## SPR EA1N and EA2 PROJECTS

### DEADLINE 5 - RESPONSES TO APPLICANTS COMMENTS AT D4 ON SASES WRITTEN REPRESENTATIONS SUBMITTED AT D1

Interested Party: SASES    PINS Refs: 20024106 & 20024110

Date: 3 February 2021

Outline Landscape Mitigation Plan

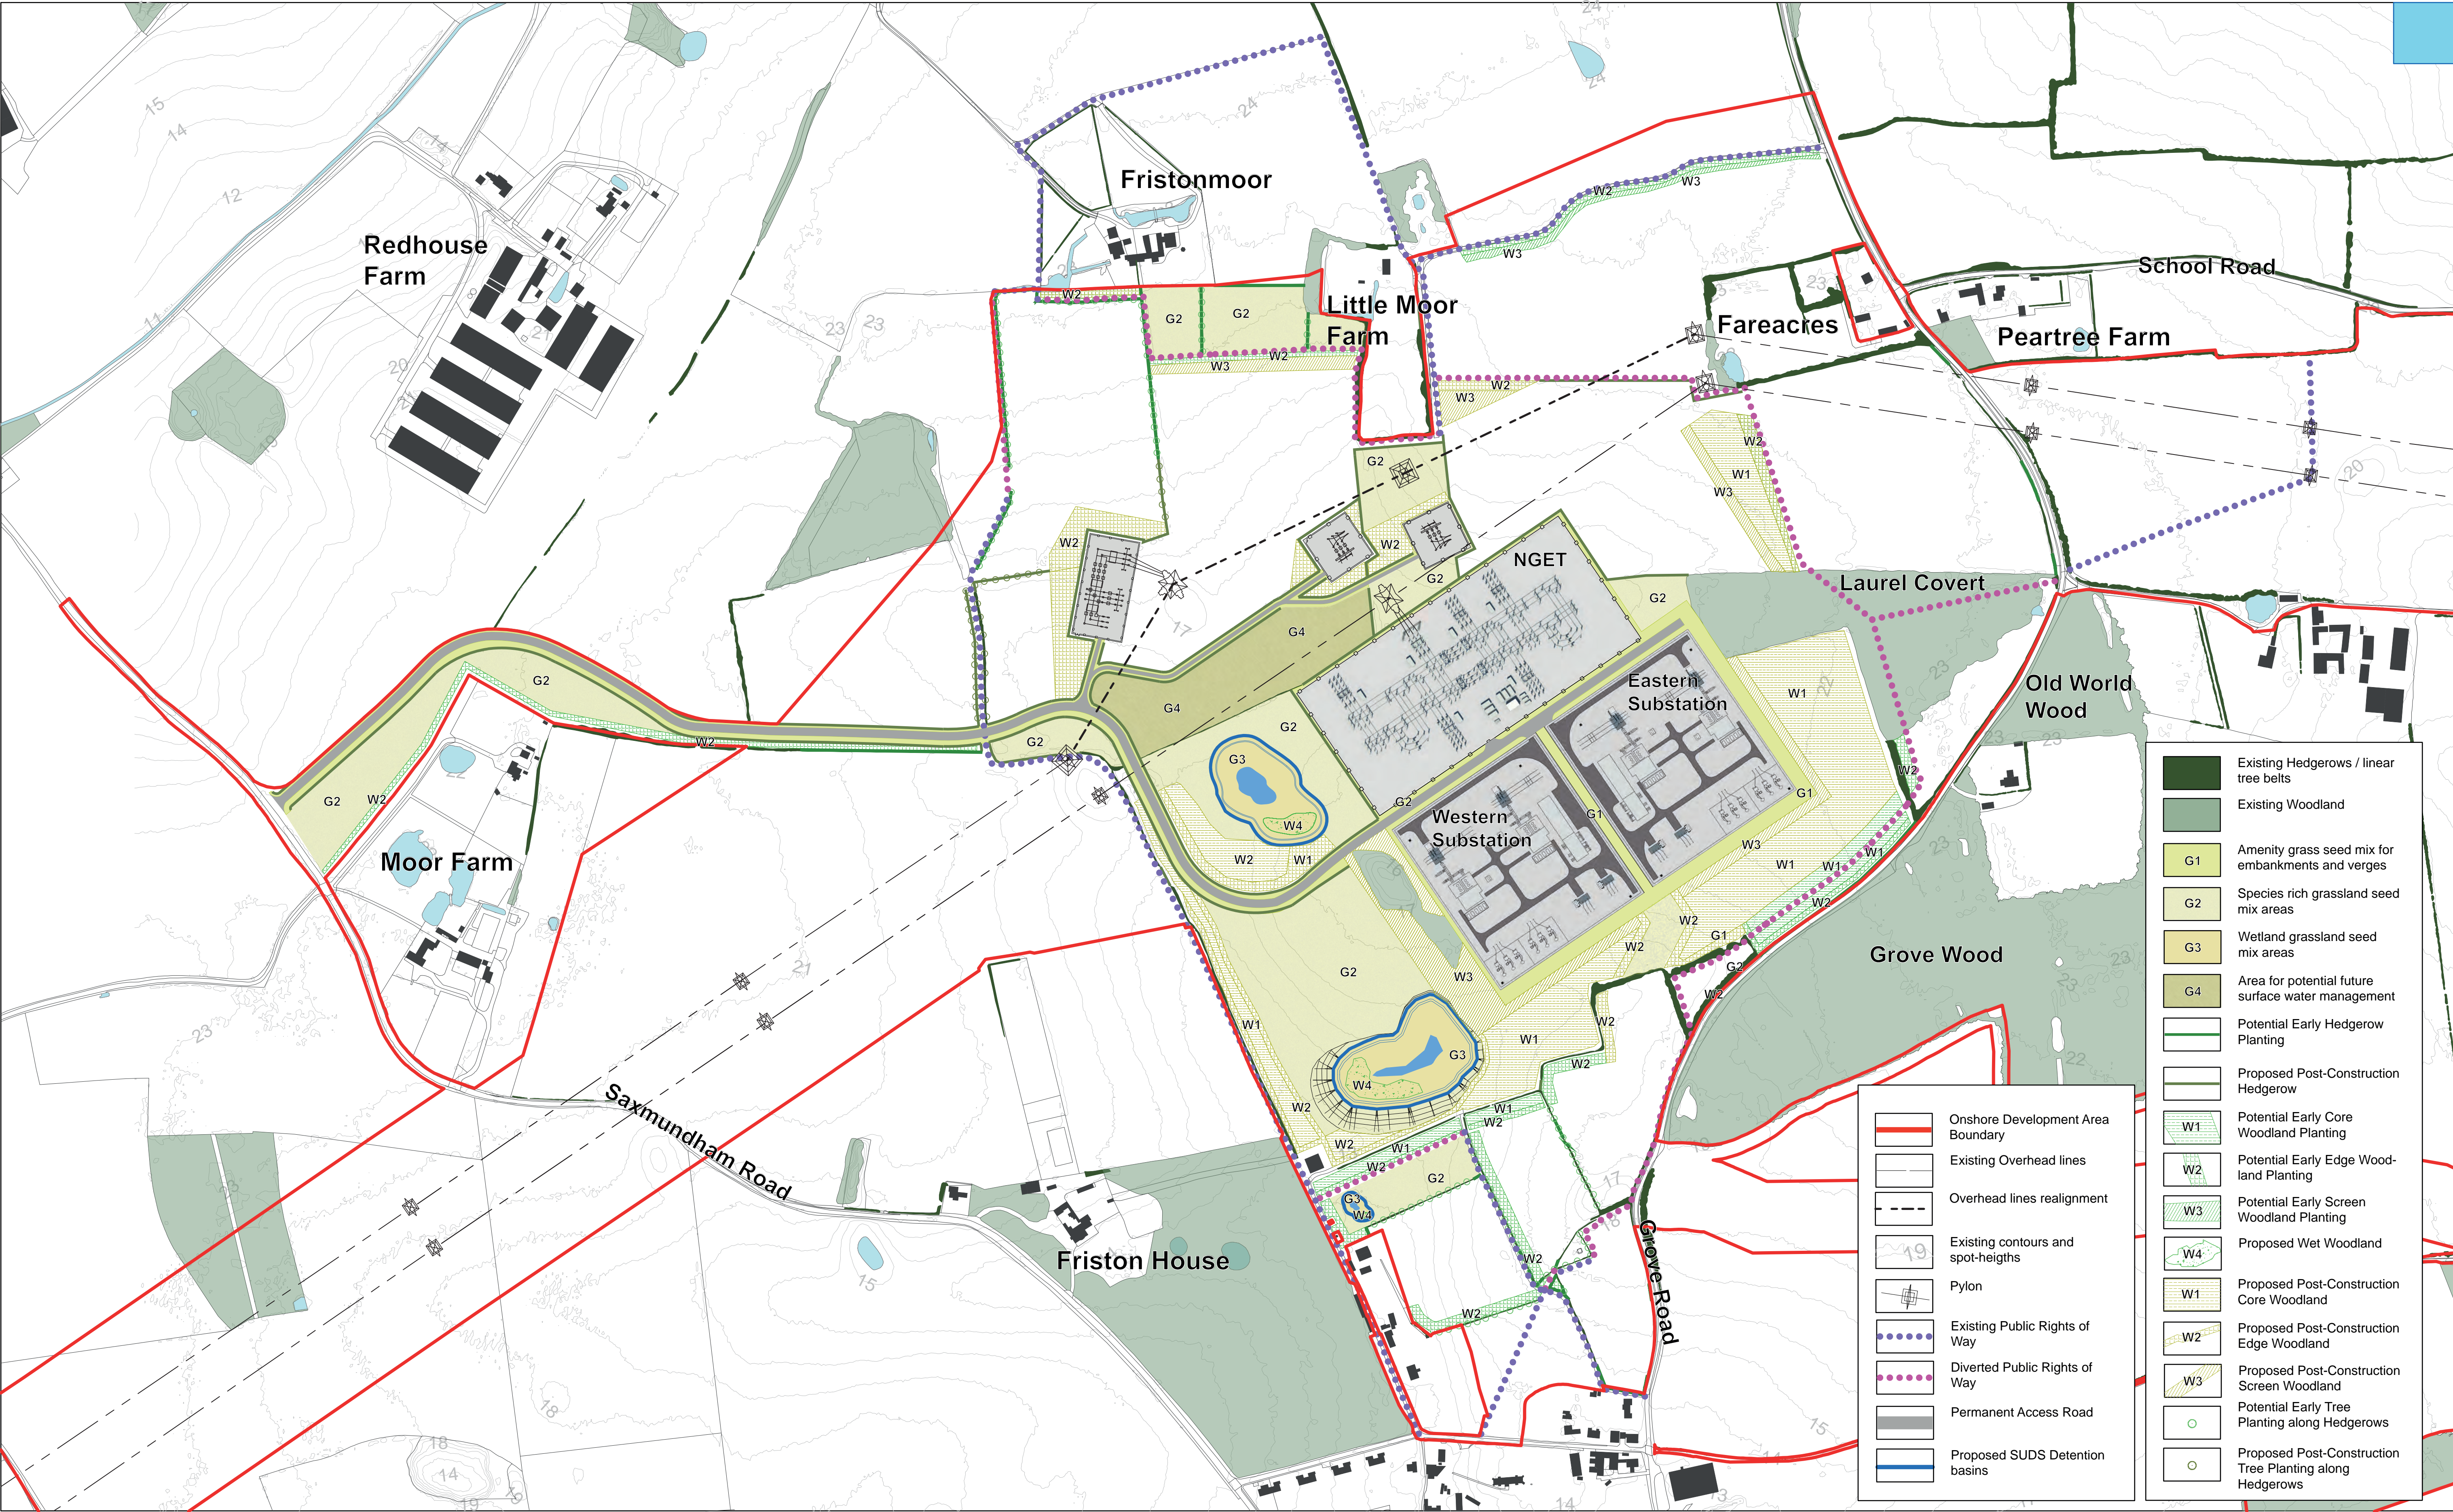
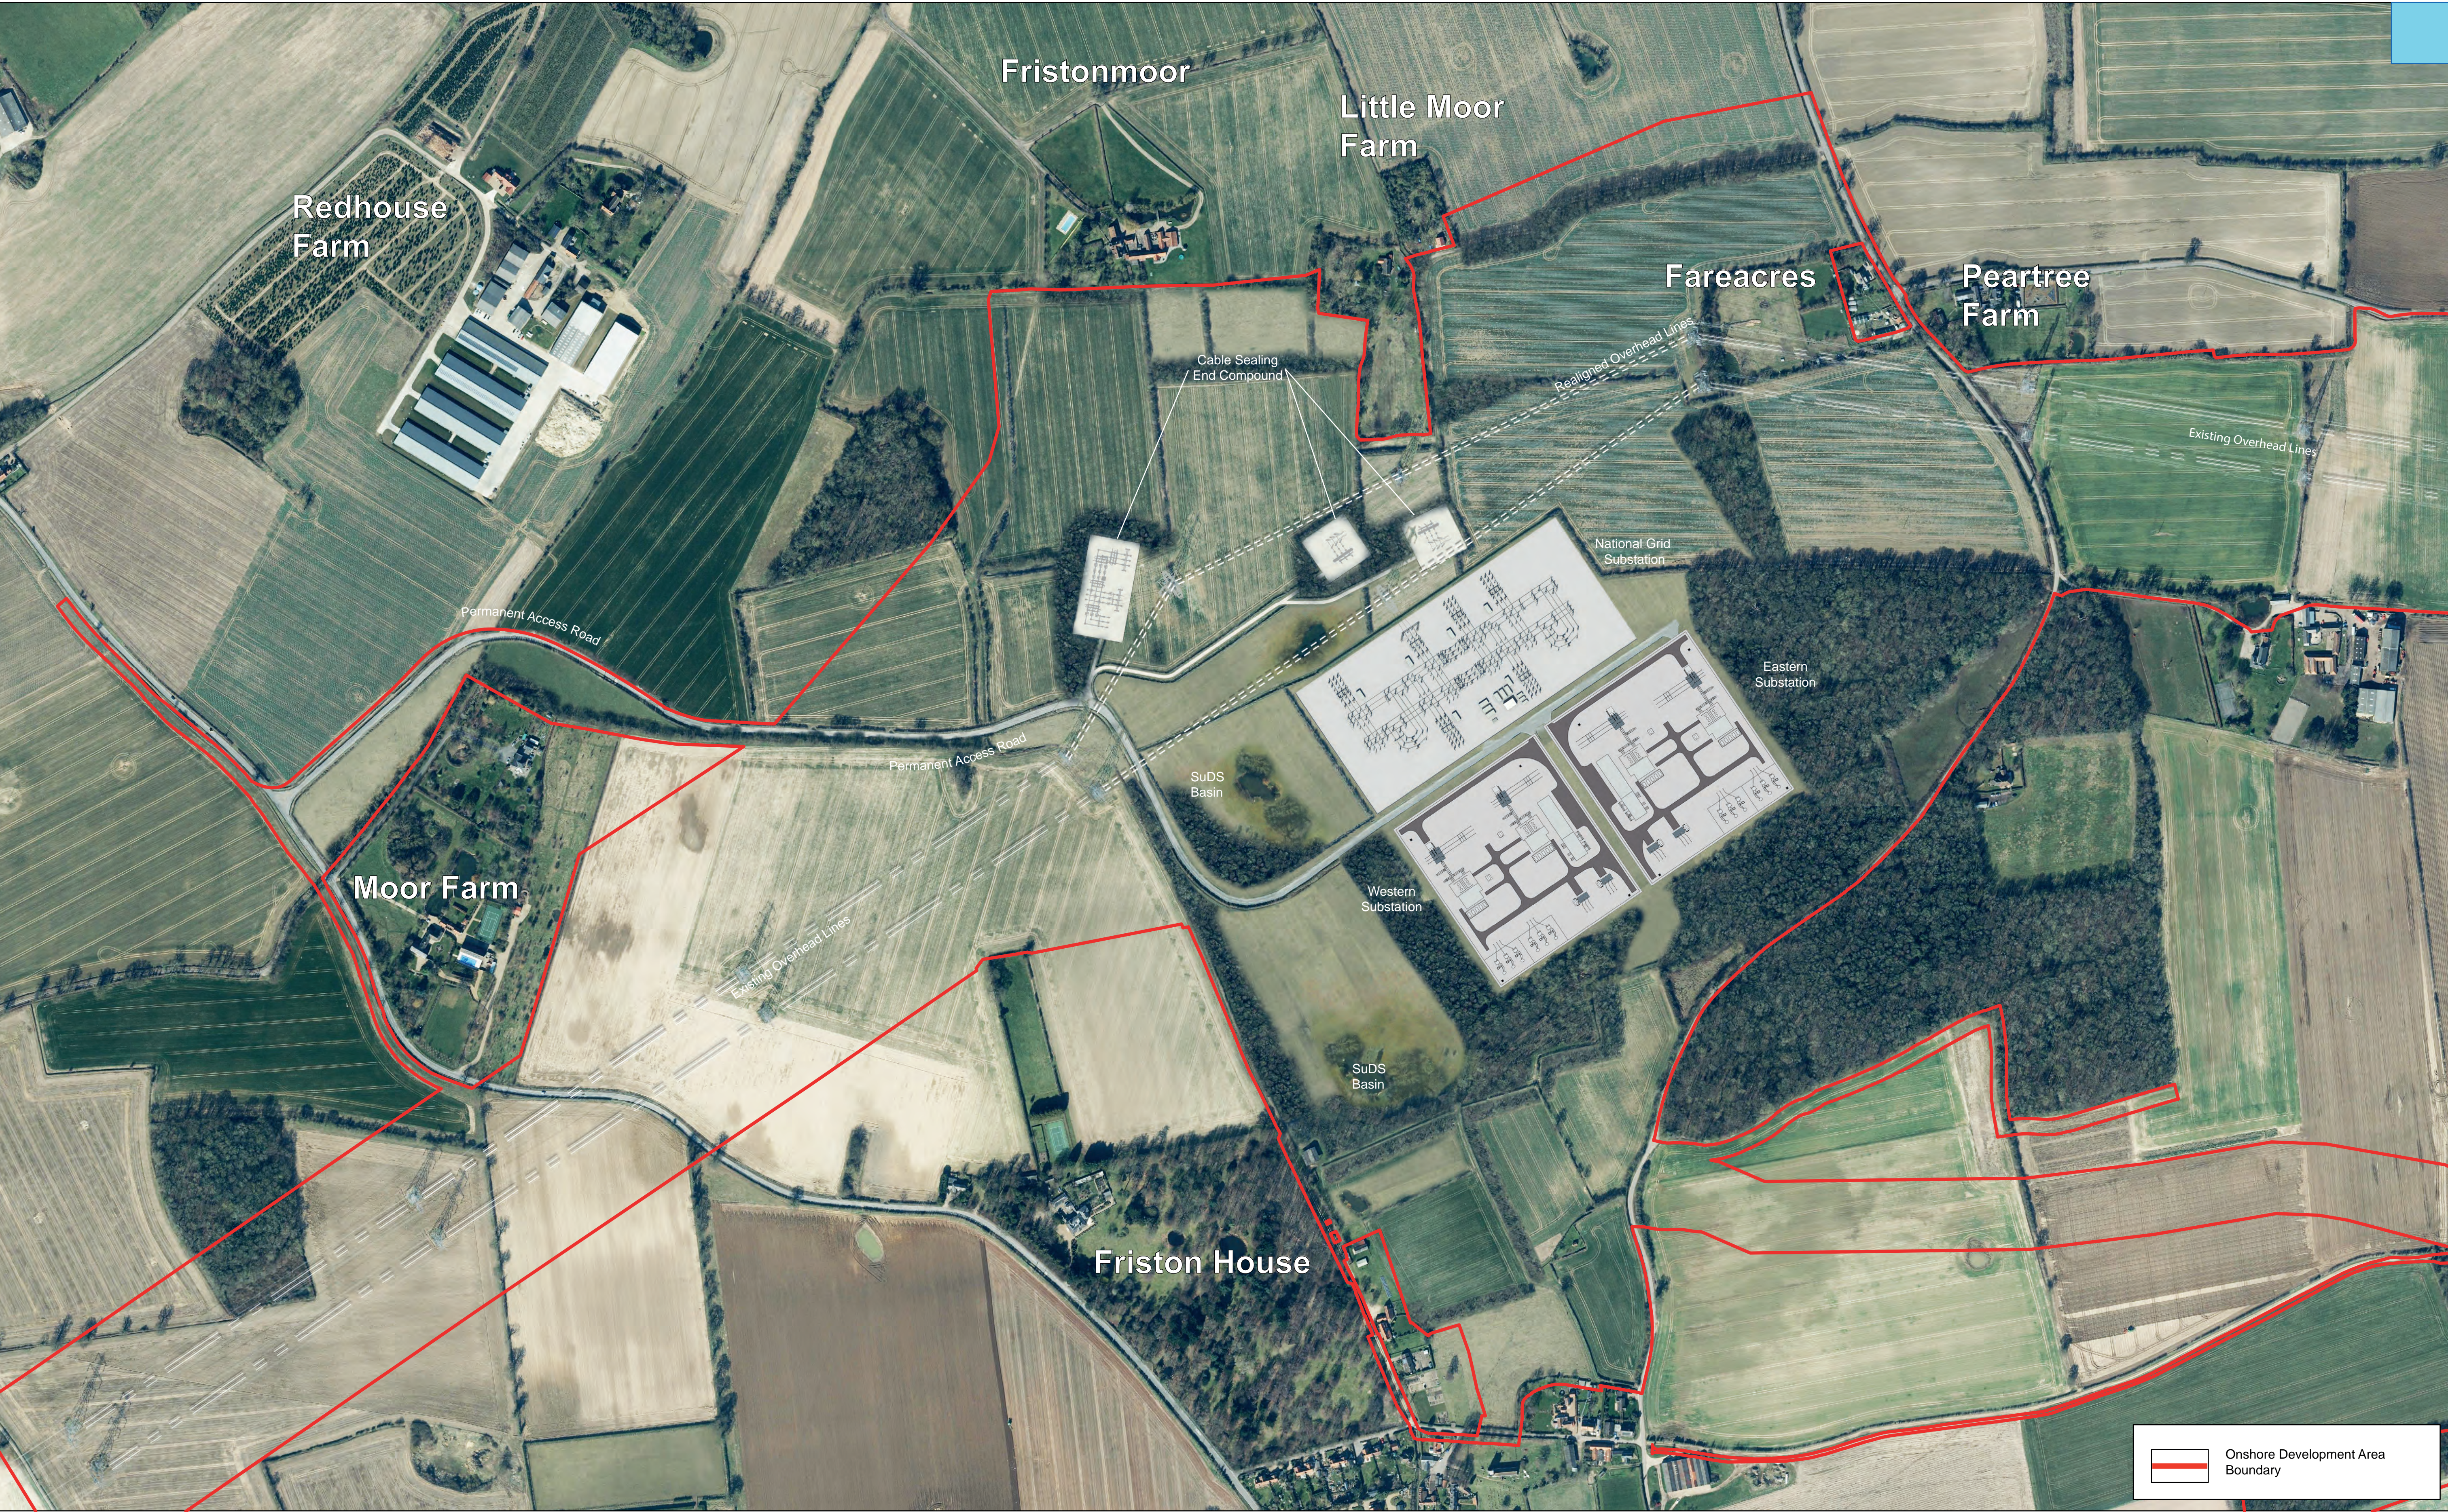
- 
4. As noted in *EN010077-003208-sases deadline 3 mb 1080 BN04 Landscape 151220* whilst the commitment to install the ducting for both projects at once along the cable route is welcomed no such commitment has been given with regard to the substations although it would clearly be a potential mitigation measure with regard to the adverse landscape and visual impacts at Friston. As a consequence, the uncertainty over both the length of the construction period and the date on which the vast majority of the mitigation planting can be implemented remains.

7. It is welcomed that the revised photomontages in the Appendices to the *Landscape and Visual Impact Assessment Addendum* now include an existing image that can easily be compared to the photomontages and that the overly optimistically 'early' planting has been omitted. It is a shame that the opportunity was not taken to revise the smooth green field with the newly planted whips/transplants in Vp 1 which, as pointed out at the ISH2, is quite unrealistic. Creating a more realistic image which acknowledged the likely soil conditions around the planting would not have been difficult. Vp 1 is also a very clear example of the limitation of the approach to showing just Yr 1 and Yr 15. The Yr 1 image is quite unrealistic and there is no real indication of how that viewpoint will look over the period that it will take for the planting to establish.
